Your ref:
Our ref: 22/00432/F
Please ask for: Miss Sandra Homcenko
Direct dial: 01553 616824
E-mail: borough.planning@west-norfolk.gov.uk

30 March 2022

Details: **Replacement of existing asbestos cement double garage with a double car port/carriage house. The building will only be used for the storage of two vehicles. at Riverside House Creek Lane Brandon Creek Southery Norfolk**

Riverside House - Existing Garage

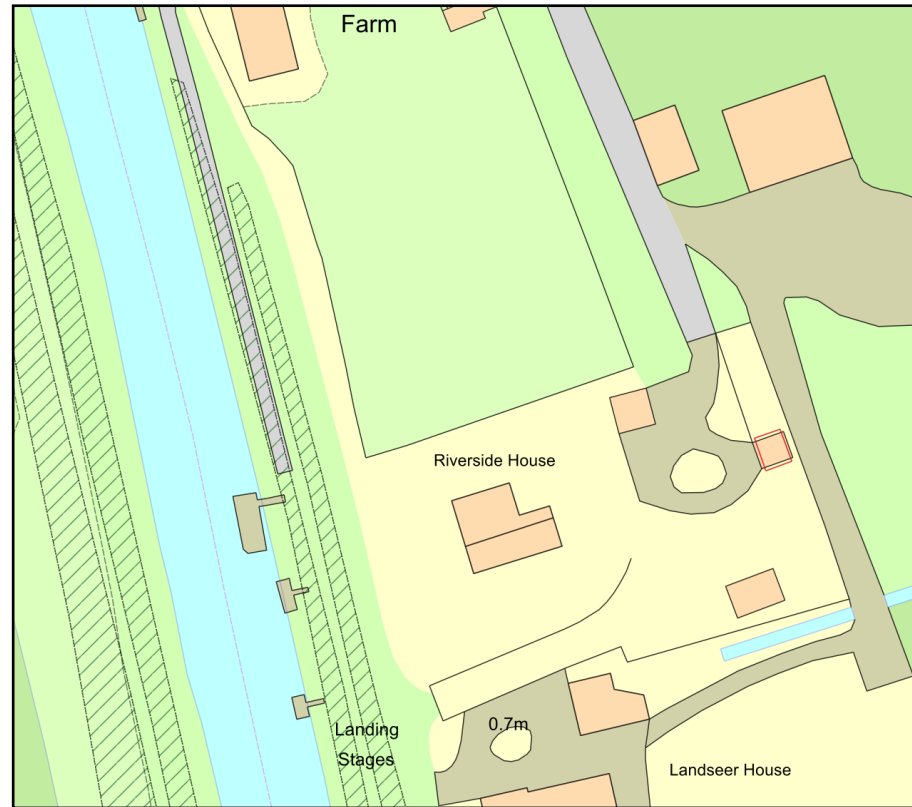
1. Apologies, however for the purposed of Planning Application you have to supply drawings to scale, please follow National Validation checklist for requirements.
2. Please correct your location plan, location plan should outline residential curtilage in red and other adjoining land in applicants ownership in blue.
